Response to ExA's Second Written Questions (ExQ2)

This document sets out the response to the Examining Authority (ExA)'s Second Written Questions and requests for information (ExQ2) by Cambridgeshire County Council (**CCC**) and Fenland District Council (**FDC**) (together, **the Councils**). The table below sets out the topic, question number and CCC / FDC's response.

**Figure 10.1i**  
**New Bridge Lane access design**

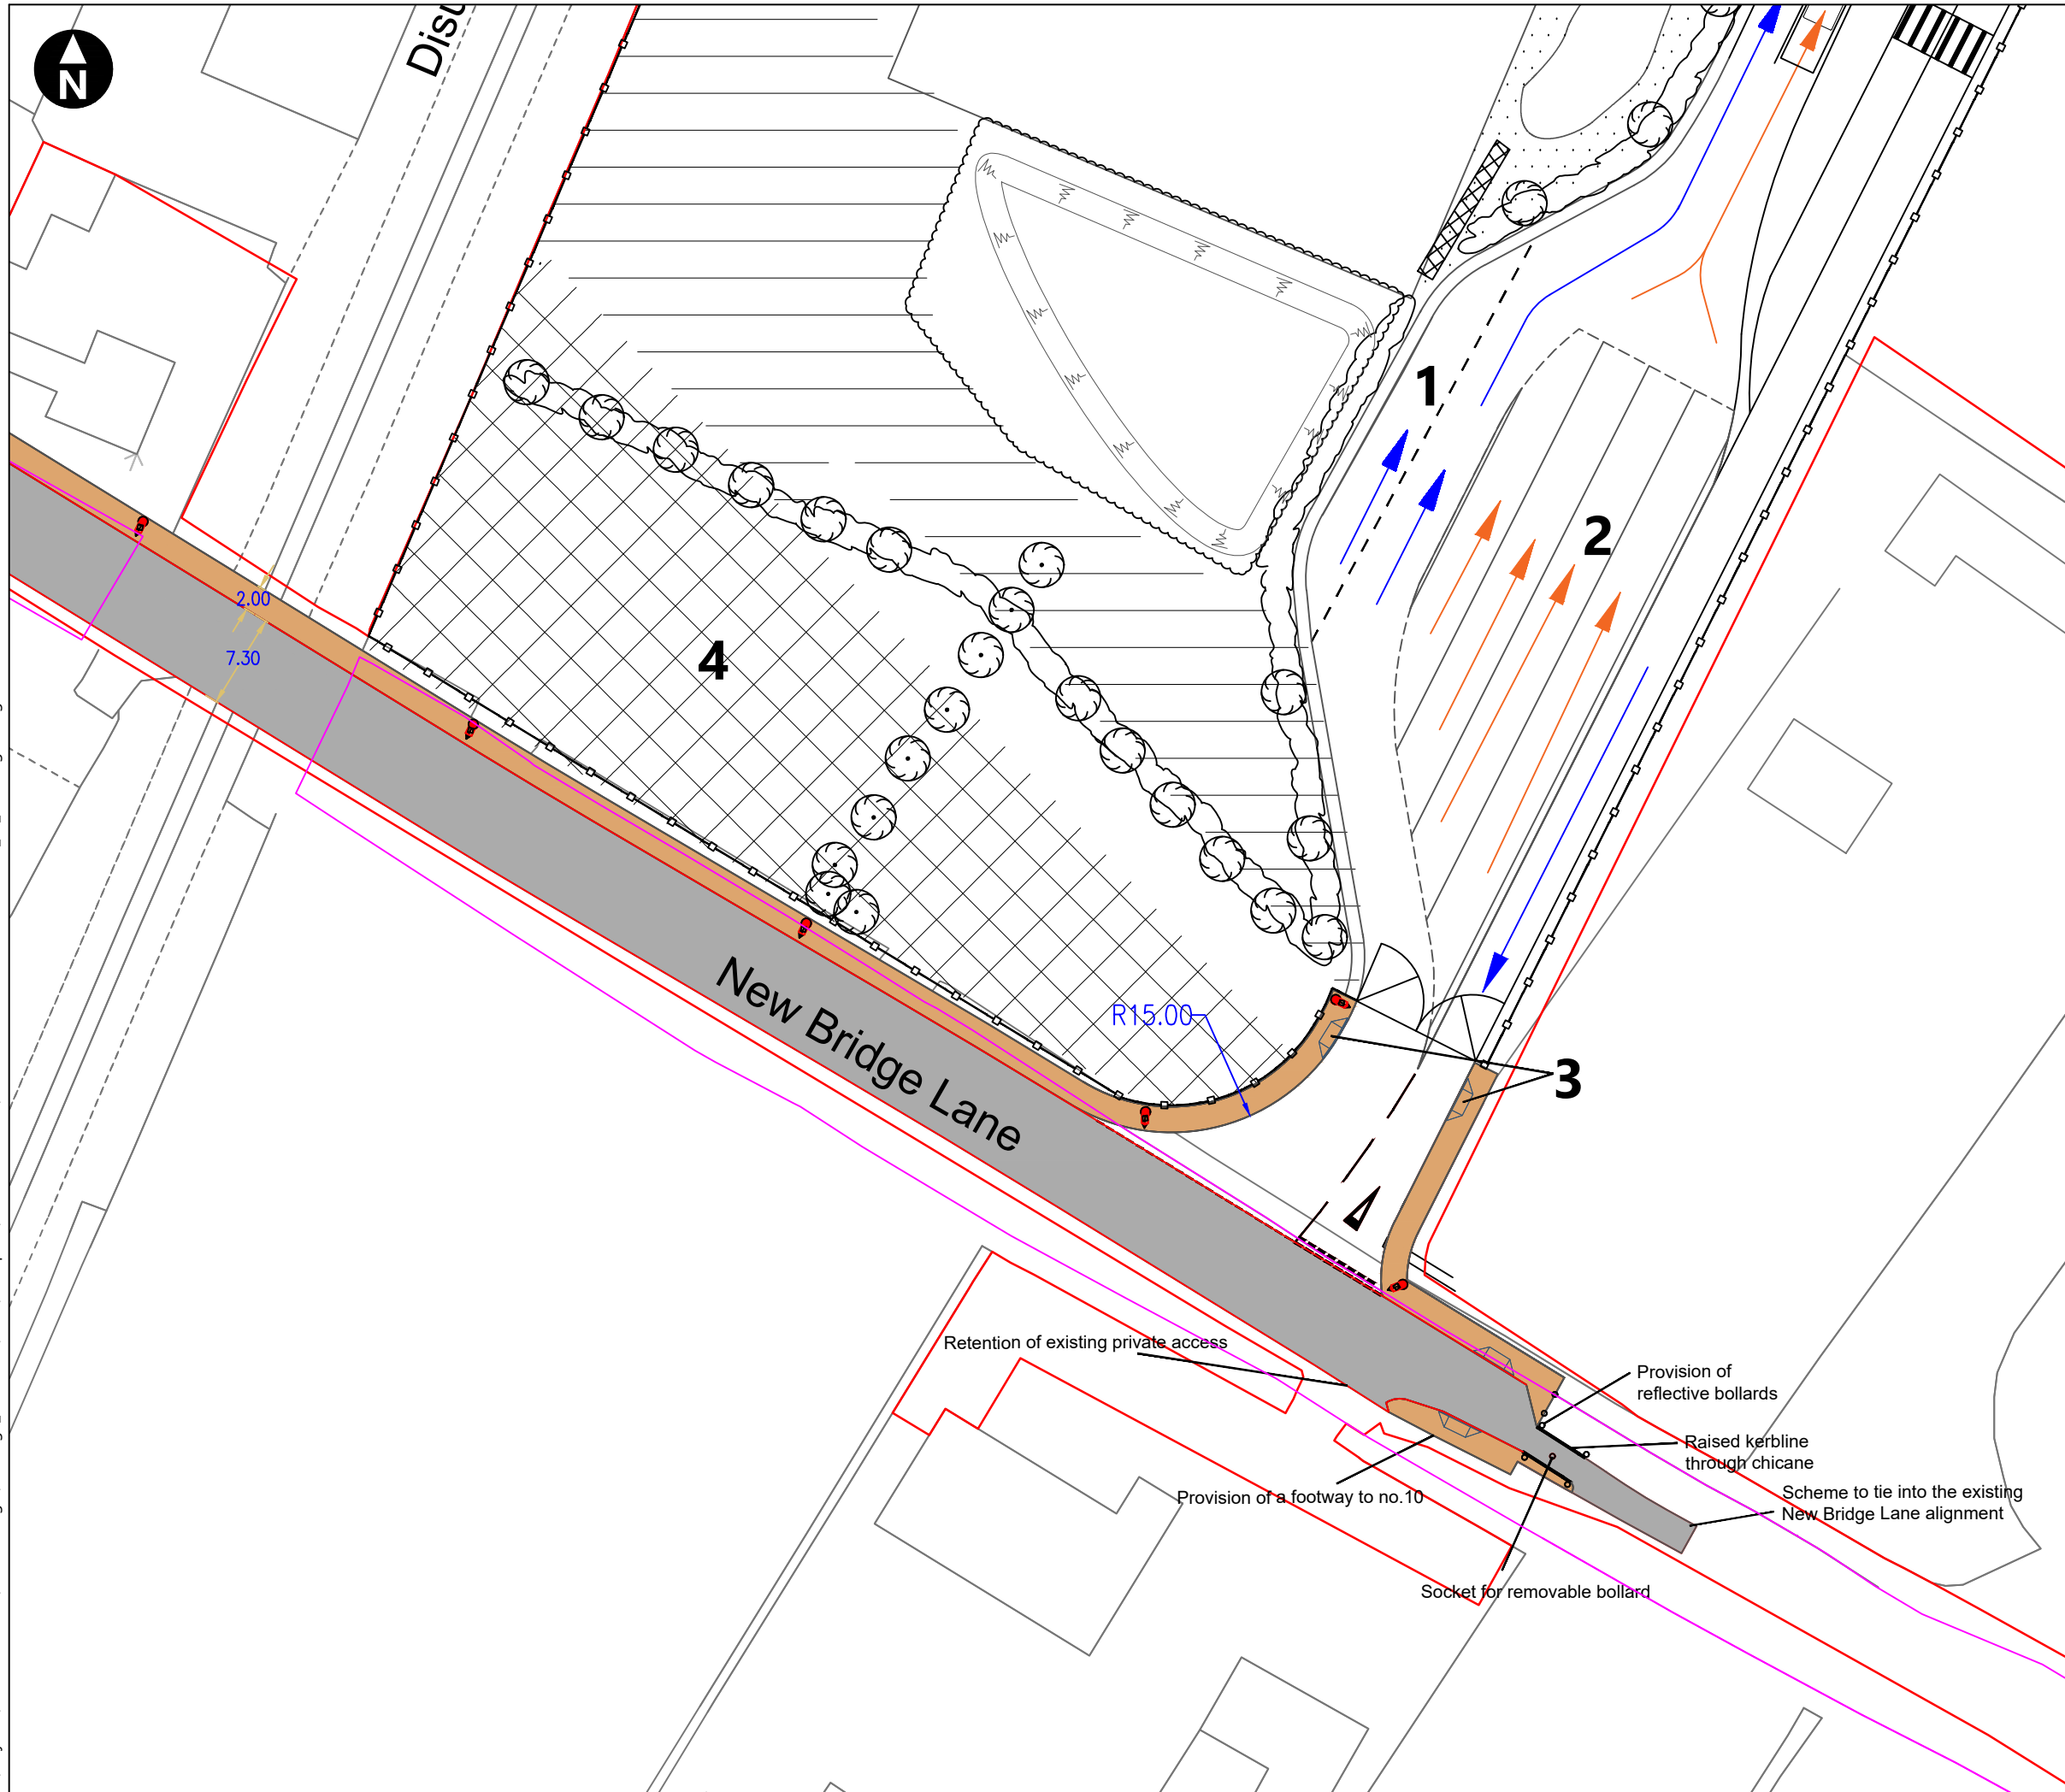
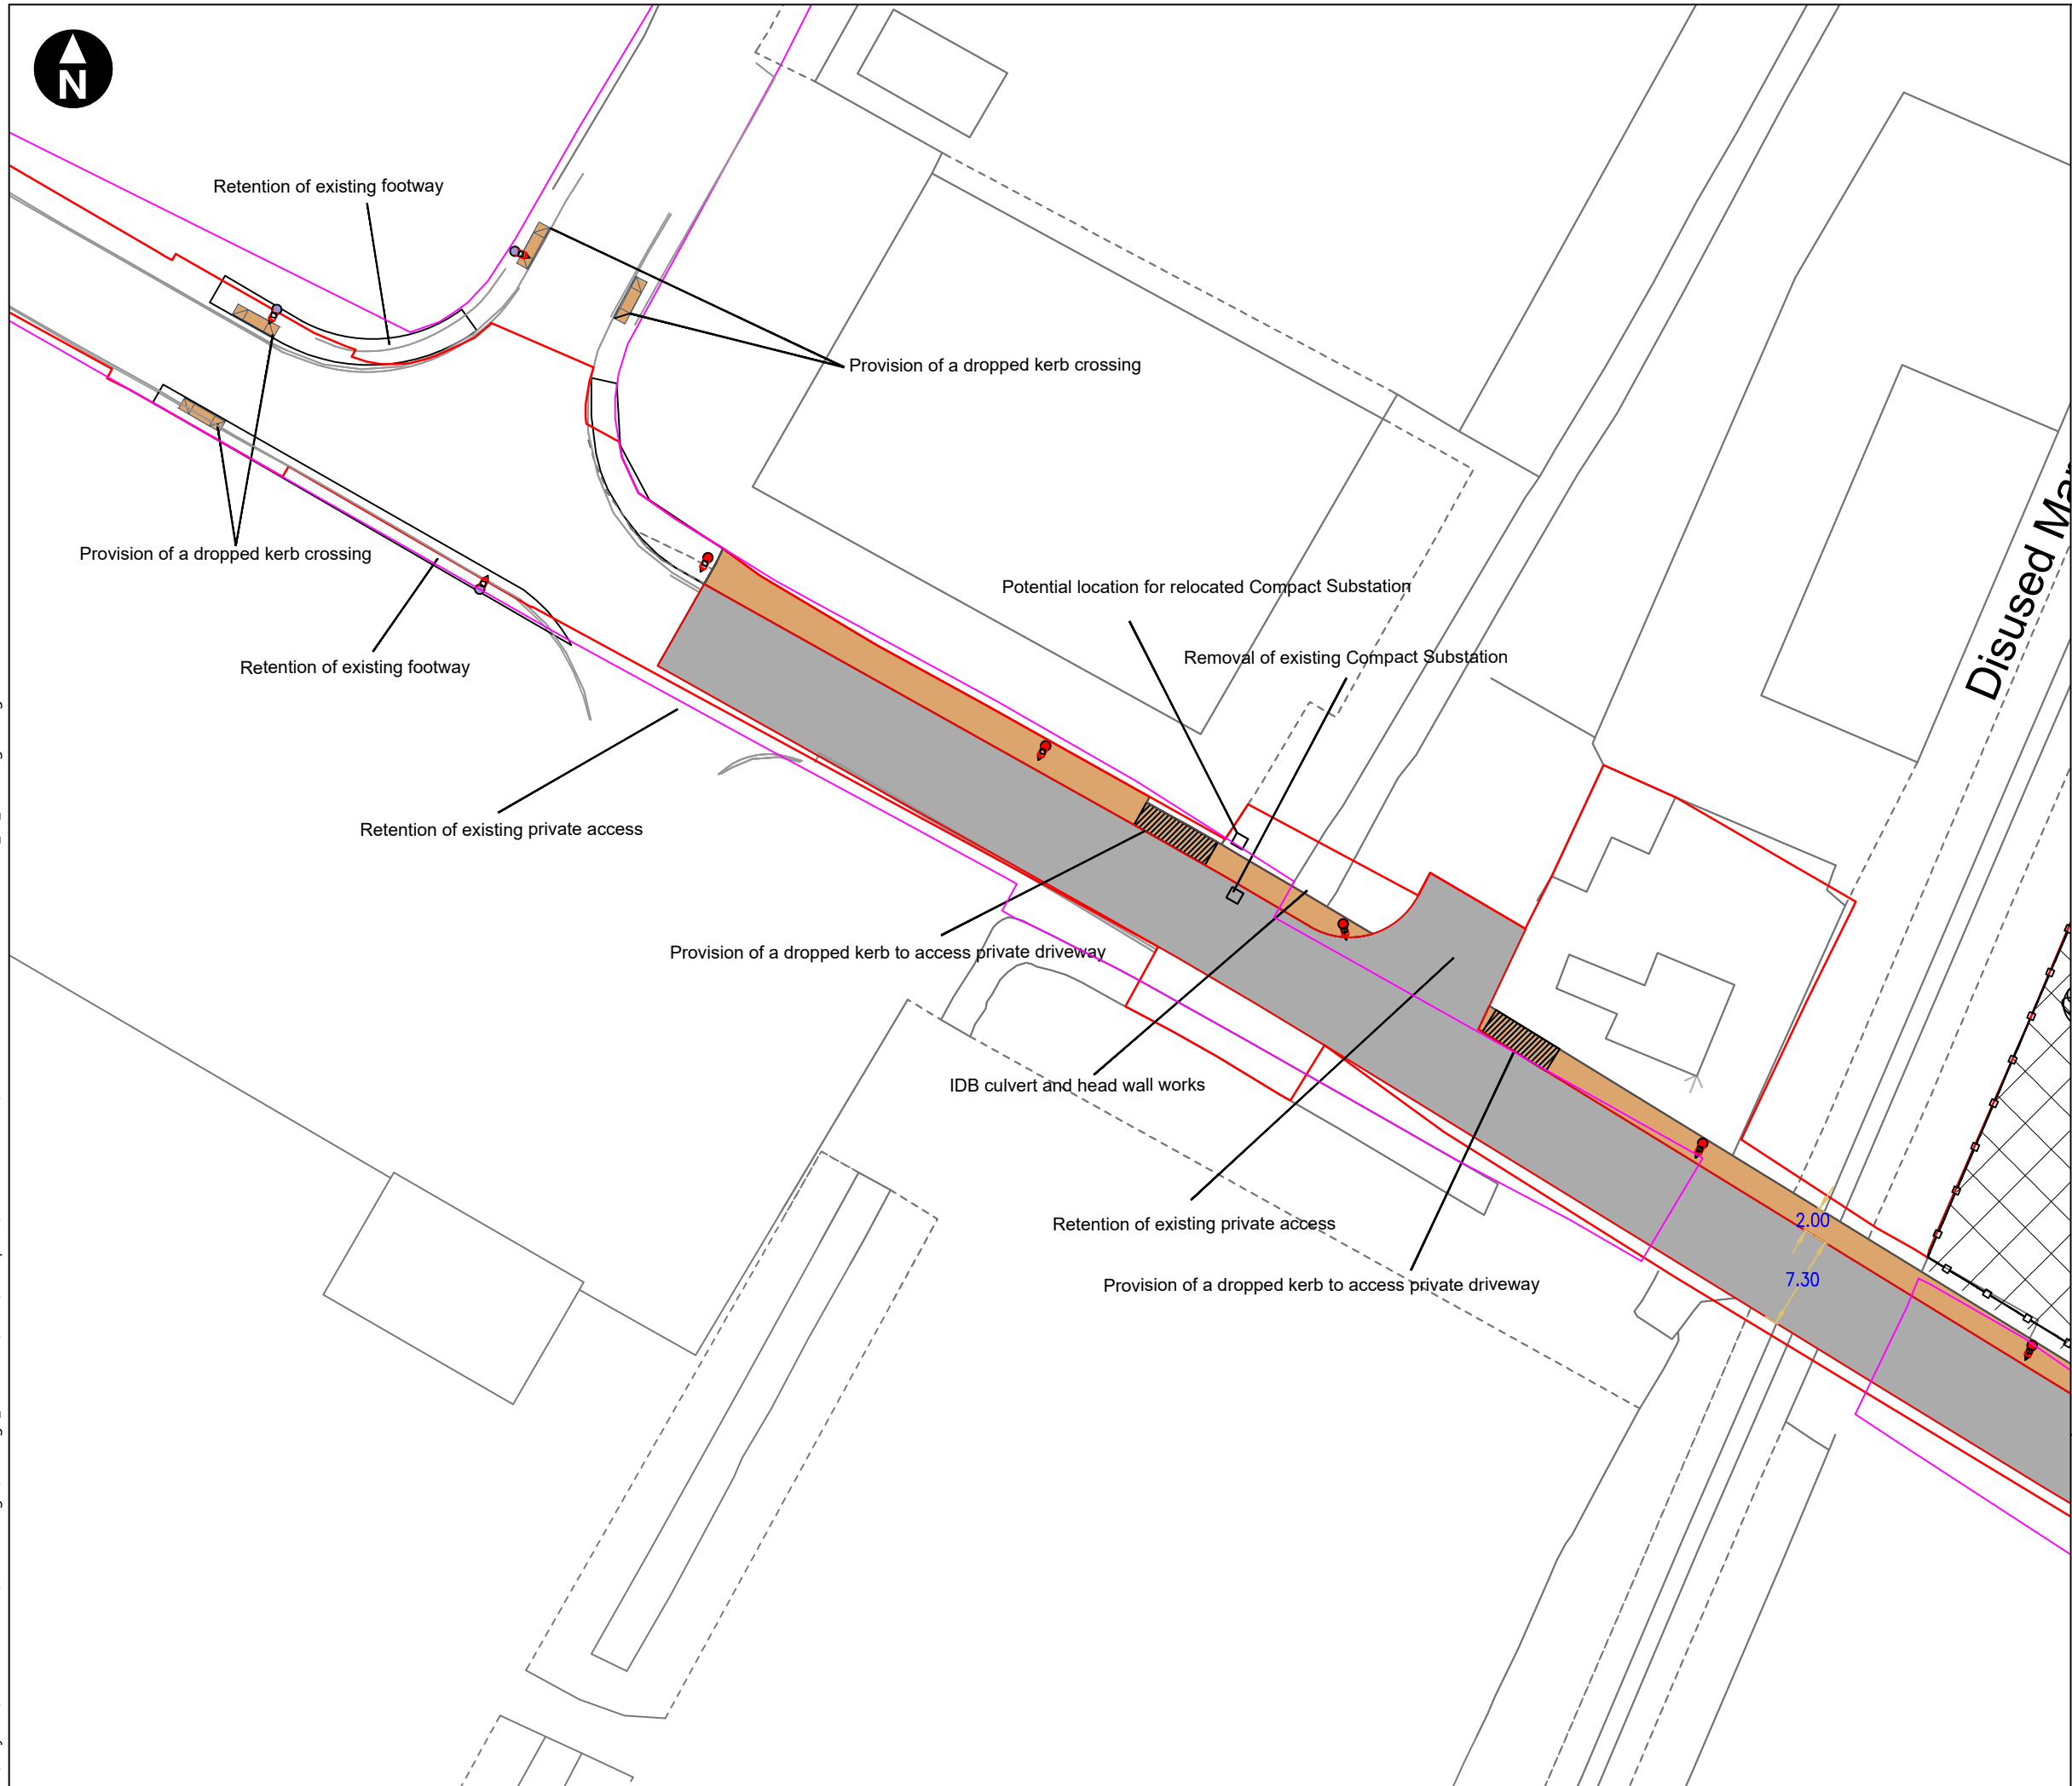
Draft Development Consent Order			
DCO.2.1	Cambs CC	<p>Action IHS2-12 [EV-032] asked for the Applicant to consider current drafting of Requirement 7 of Schedule 2 and to provide further explicit reference within the requirement of the works proposed and the approved details, in line with Cambs CC's comments.</p> <p>In its response to IHS2-15 [REP3-038], the Applicant stated that the amendments had been made to address this issue in the dDCO [REP3-006]. Can Cambs CC please confirm that it is content that the amendments as drafted address their concerns on this point?</p>	<p>CCC can confirm it is content with the amendments to Requirement 7 of Schedule 2.</p>
DCO.2.2	Applicant Cambs CC	<p>In response to action ISH2-13 [REP3-038], the Applicant has stated that prior to Deadline 3, it met CCC to discuss highway matters on the 13 April 2023 and is liaising with them regarding predevelopment condition surveys and s278 obligations.</p> <p>Can the Applicant and Cambs CC please update the ExA on any developments following from Deadline 3?</p>	<p>The Applicant and representatives of CCC have met on more than one occasion since ISH2. The Applicant has engaged CCC on the matter of s278 obligations and these are currently under negotiation. CCC's comments on the Applicant's draft s278 terms were returned to the Applicant on 31 May.</p> <p>CCC still awaits further engagement on the matter of pre-development condition surveys, but would note that the most recently published version of the outline CTMP [REP4-007] does not fully satisfy the concerns previously raised.</p>

<p>permission is in the gift only of Network Rail, this is a simple request that would bestow a significant benefit for local communities.</p> <p>The signage and any agreement should be in place upon completion of the proposed works to the crossing as part of the New Bridge Lane improvement works, prior to the commencement of operation.</p> <p>4) A S106 Legacy Fund has also been discussed with the Applicant to help address CCC's concerns over planning policy requirements. Negotiations are ongoing.</p> <p>With regard to NPS EN-1 para 4.1.8, the Councils understand that, had this guidance been available to the Applicant two years ago when they were drafting their proposal, they would have been able to take it into account for implementing mitigation along the lines proposed at element 1 of the Councils' list. However, unfortunately, the Councils understand that the draft DCO is now too advanced for it to be amended to accommodate this provision. This would have been the Councils' preferred approach, as it would create greater certainty and would significantly reduce the burden on the Councils involved in delivering the NMU enhancements. The problem faced is that any land that might be put forward for BNG or over which public rights might be created will all be outside the Order Limits, which would require a material change to the DCO. The Applicant would also need time to approach any third parties concerned. If this option is not available to the Applicant, it is critical that the mitigation package is securely devised and that it includes recovery of all the Councils' costs incurred in implementing it.</p> <p>The Councils would like to see the Applicant committed to making efforts to include private sites such as those suggested</p>
